## WEST SUSSEX COUNTY COUNCIL CONSULTATION

<b>TO:</b>	Arun District Council FAO: Harry Chalk
<b>FROM:</b>	WSSC – Highways Authority
<b>DATE:</b>	6 February 2026
<b>LOCATION:</b>	44 and 44A Pagham Road Pagham PO21 4NP
<b>SUBJECT:</b>	P/5/26/PL 1 No 4 bed chalet bungalow and alterations to existing bungalow to include off street parking (resubmission following P/118/25/PL). This application is in CIL Zone 4 and is CIL Liable as a new dwelling.
<b>DATE OF SITE VISIT:</b>	n/a
<b>RECOMMENDATION:</b>	Advice

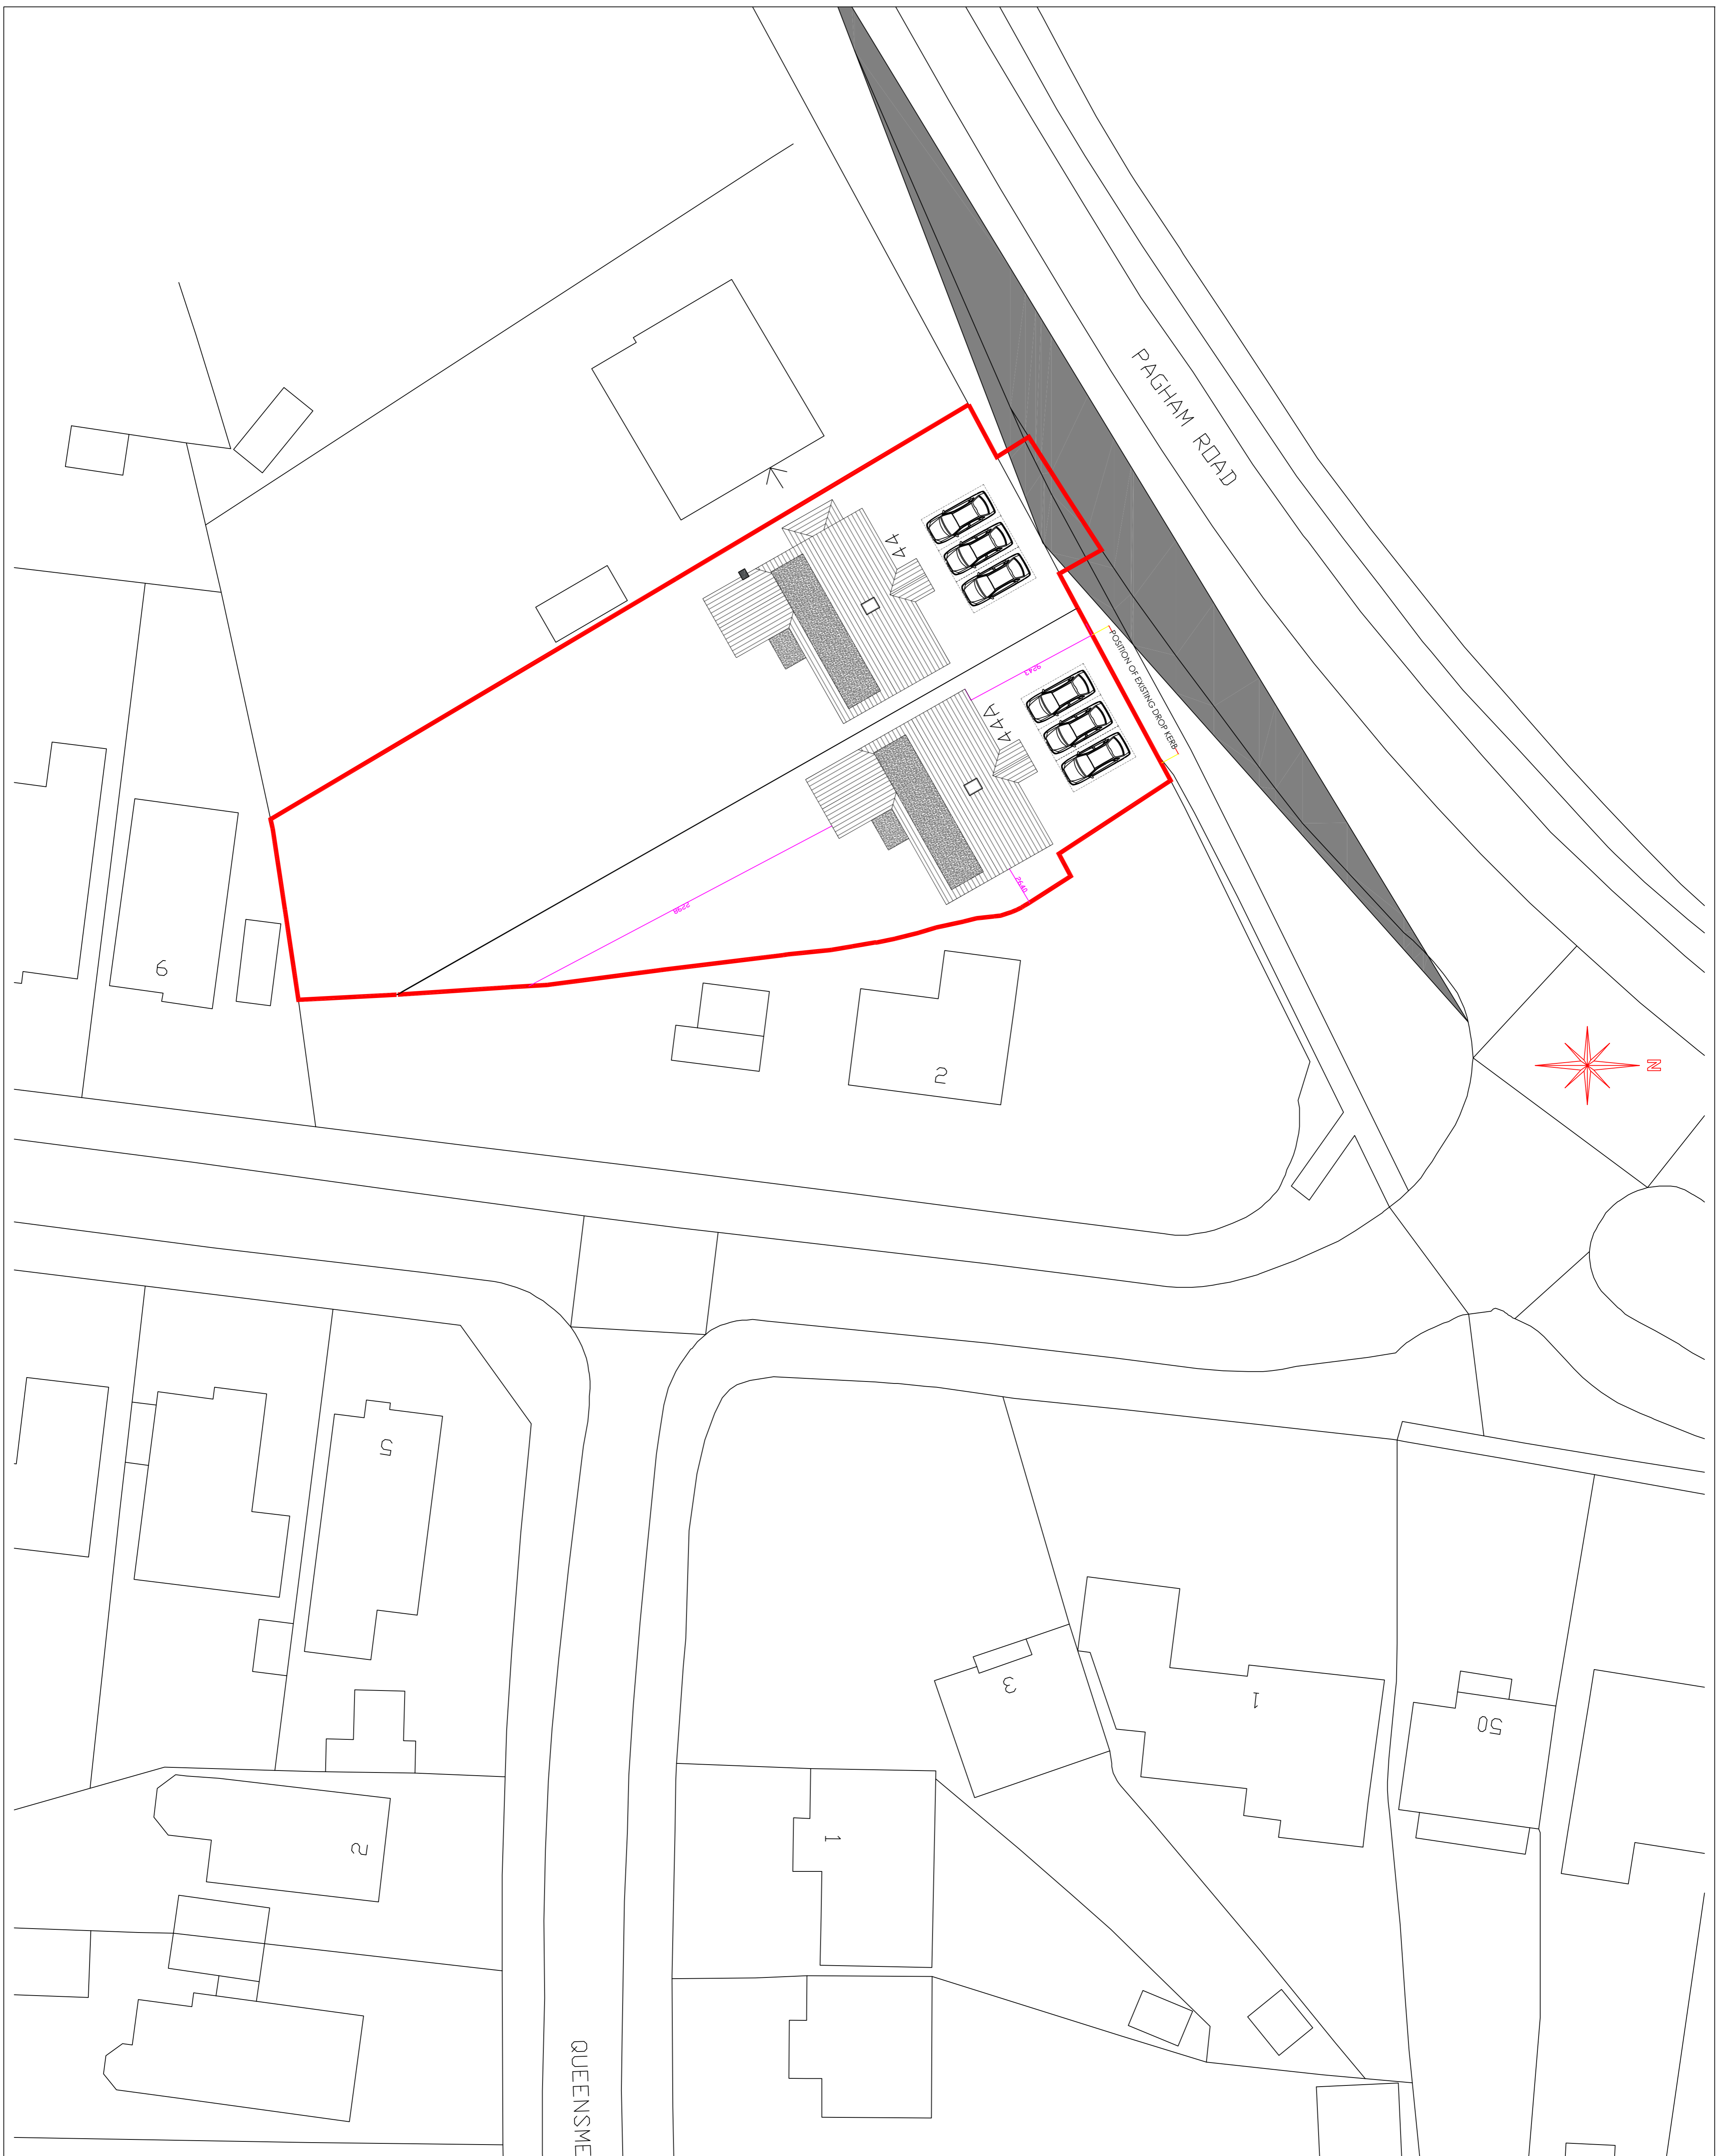
The proposed plans indicate that the new dwelling will utilise the existing access serving the host dwelling and a new access will be constructed to provide parking for the existing dwelling. Details of access can be secured via condition, and any access works must be constructed under licence, to a specification agreed with the WSSC Area Engineer.

Visibility at the existing access is considered sufficient for the anticipated road speeds and the proposal is not anticipated to result in a material intensification of use of the existing access. Some form of visibility splay has been demonstrated at the proposed access; however, this has not been annotated. The LHA would expect splays of 2.4 x 43m to be provided at the proposed access point, in accordance with Manual for Streets. However, an inspection of WSSC mapping indicates that these splays are achievable and maintainable wholly within the public highway in this location.

The plans indicate that three parking spaces will be provided for each dwelling. The WSSC parking demand calculator would expect that this is sufficient provision for a development of this size and location.

The site is located within walking distance of shops and services, including bus stops providing links to Bognor Regis and Chichester. Cycling is a viable option within the vicinity and secure and covered cycle storage should be provided for the proposed dwelling. The LPA may wish to consider whether alternative cycle storage provision is required for the host dwelling, given the loss of the garage building.

No part of the development shall be first occupied until such time as the vehicular access has been constructed in accordance with plans and details to be submitted to and approved in writing by the Local Planning Authority.

No part of the development shall be first occupied until the car parking has been constructed in accordance with the approved site plan. These spaces shall thereafter be retained at all times for their designated purpose.

No part of the development shall be first occupied until covered and secure cycle parking spaces have been provided in accordance with plans and details to be submitted to and approved by the Local Planning Authority.
